From: Simon Davis
Sent: 05 September 2018 11:57
To: 'Planning JPA'
Subject: RE: Update on application FP/171/18/PL

Layout & Design

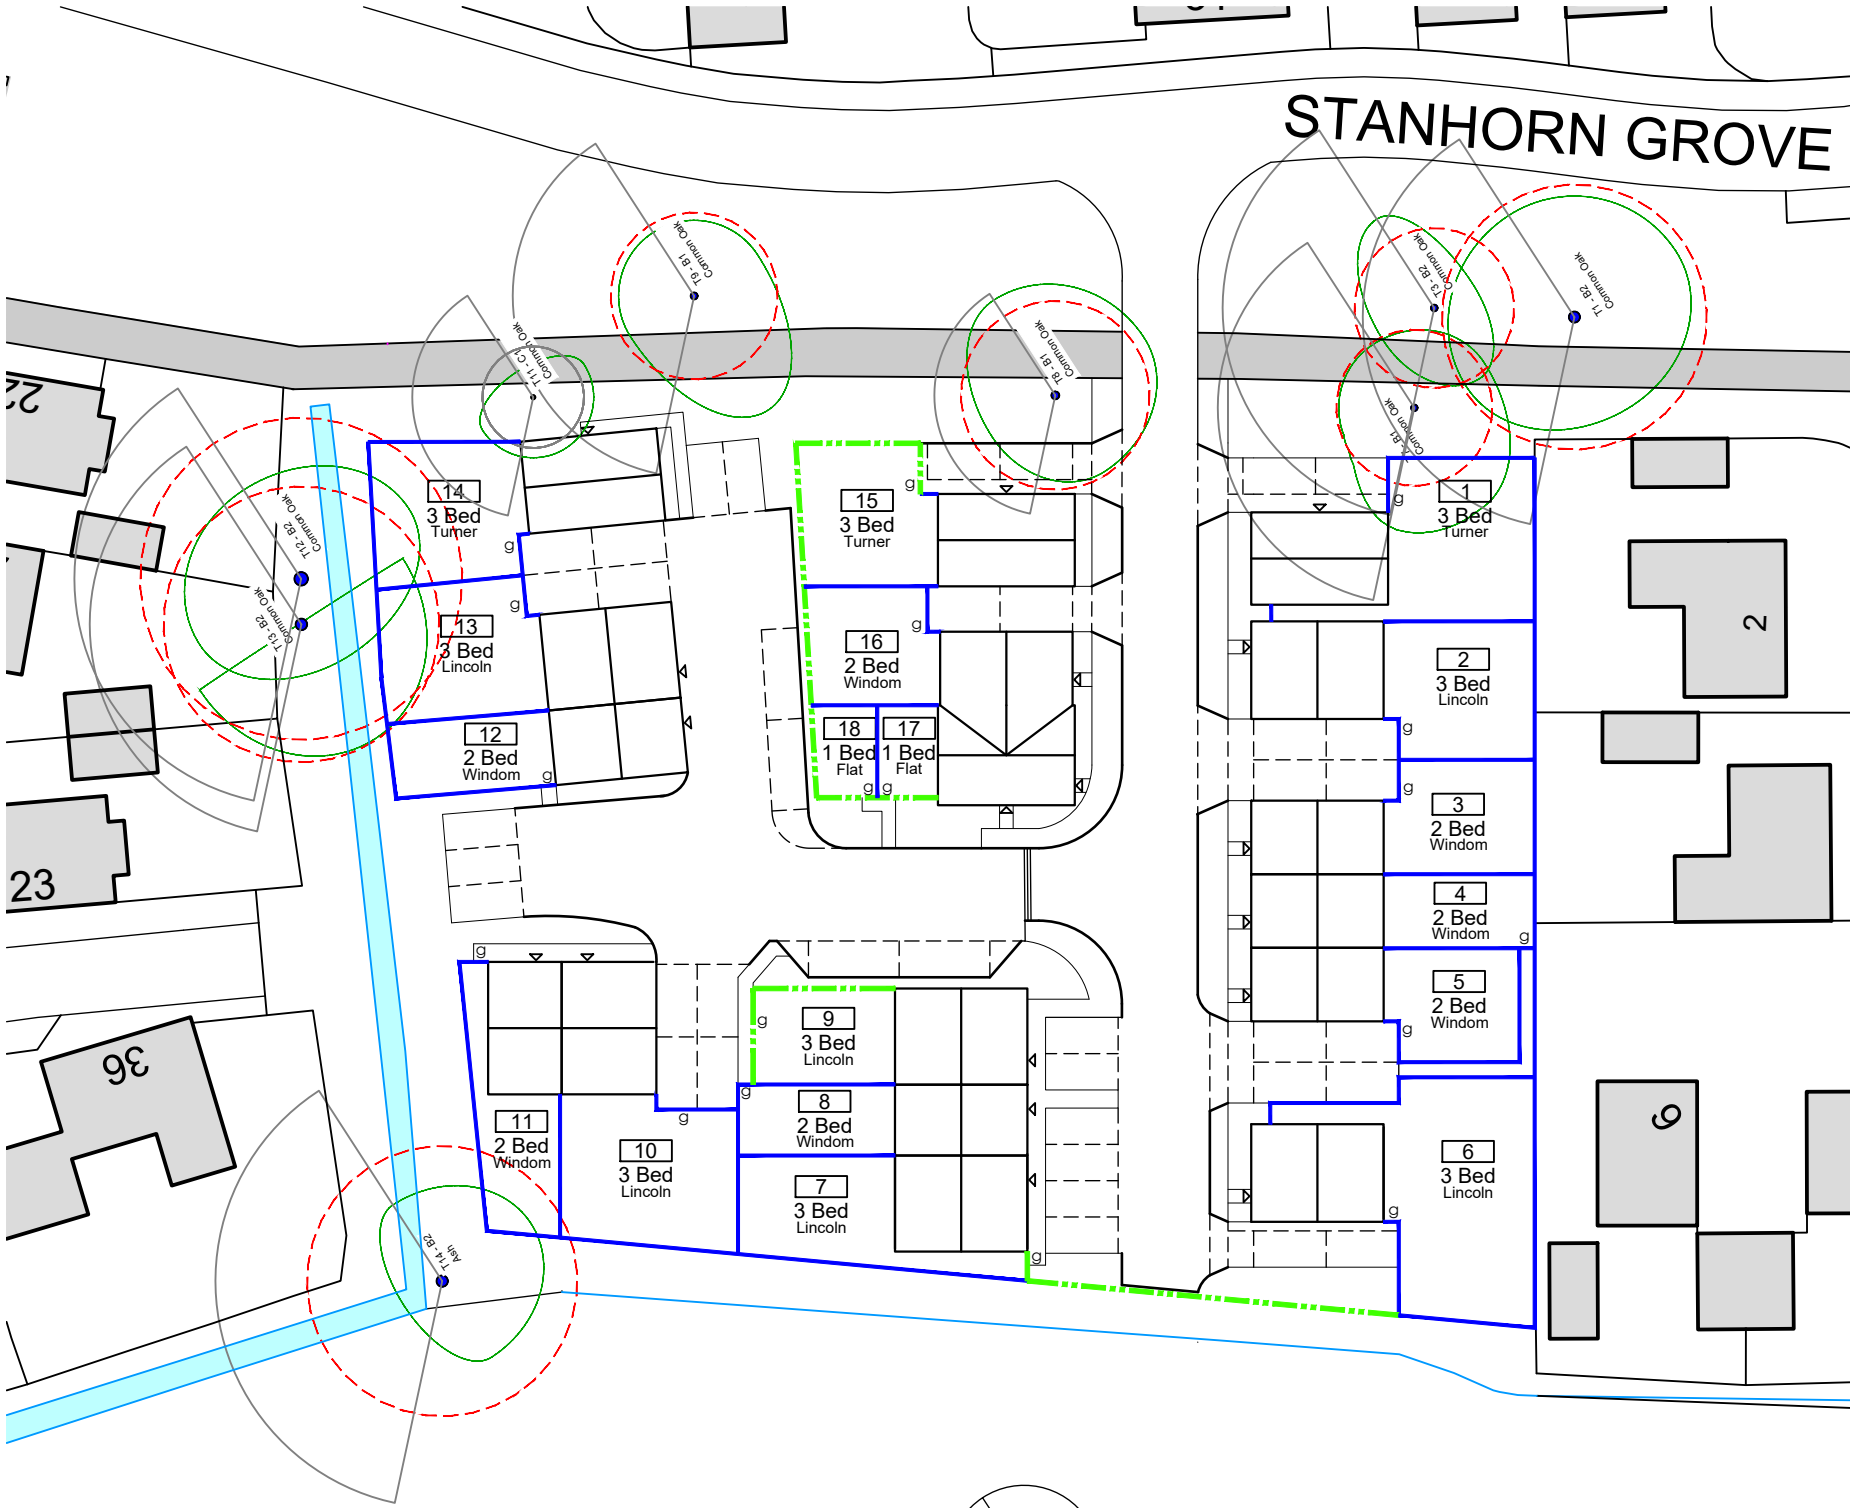
- (1) Can you amend drawing 17094-PL-2-07 (and any related drawings) to show brick walls/brick & timber panels to the fronts of plots 1 and 14 as per plot 15.
- (2) The interface distance between the rear of plots 3-5 and the rear of 4 Weller Close is a bit tight. Can you move plots 3-5 forward by 1m at the expense of part of the front landscaping strip.
